Re – Planning Application – 2022/93947 – 412 Birkby Road.

We note that this new application is to move the garage of 412 Birkby Road back to the original proposed position as previously rejected by Kirklees planning as part of application 2021/91239.

client	MR S.HANDA		
project	PROPOSED GARAGE 412 BIRKBY LANE HUDDERSFIELD HD2 2DN		
drawing	PROPOSED SITE PLAN		
revision	notes	date	drawn
scale :	1:200 AT A1	12.22	-
project no.	2189	drawing no.	02
		revision

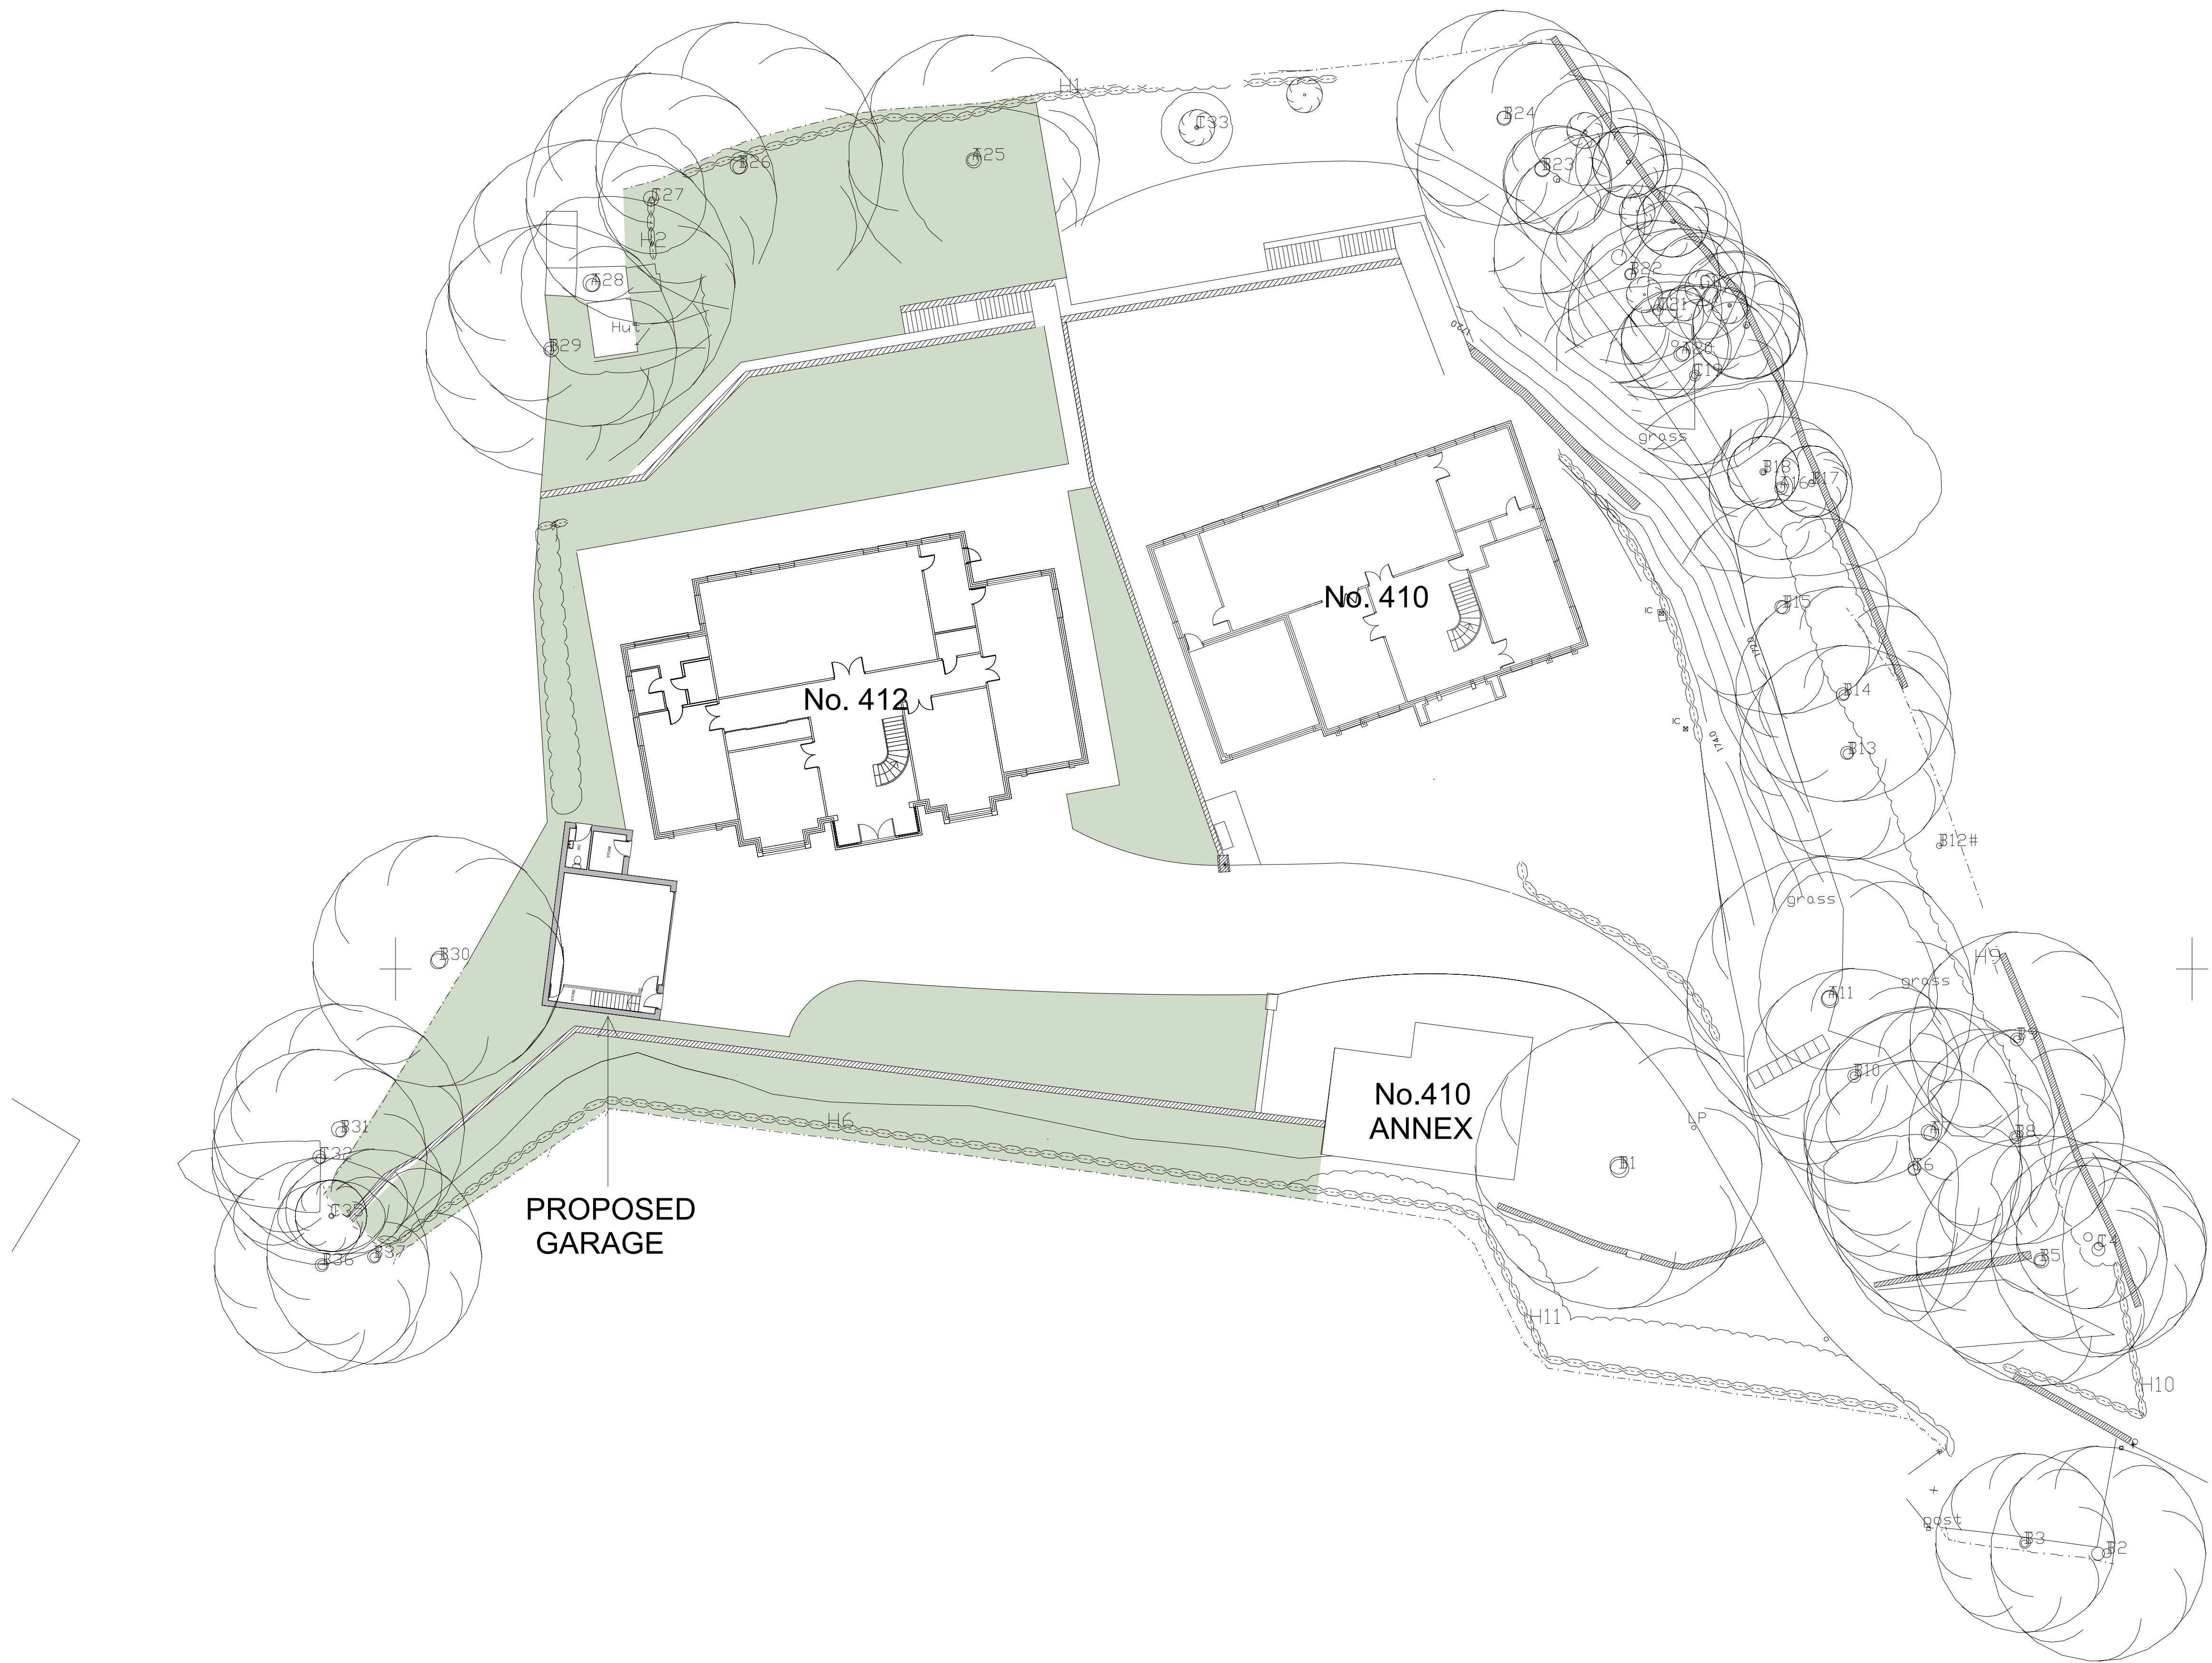
The requested position will still interfere with the tree previously designated T30 in the initial application (2021/91239) and the plans for this application, T1 in the Arboricultural report (971505) accompanying this application.

As stated previously in other objections the reason the garage was moved from that location was because the Tree Officer, Nick Goddard was concerned that building in that location would damage the roots of this tree. His report dated 26 May 2021 states: 'The garage on the western side is within the rooting area of a large mature tree and requires loss of rooting area which is also not acceptable'.

This suggests to me that the current work has already encroached into the Tree Protection Area (TPA) , what has Kirklees done to stop work and ensure no further damage is done to this or other trees?

We object to these plans and request that Kirklees Council also reject the application on the grounds that they had previously rejected this part of previous plans.
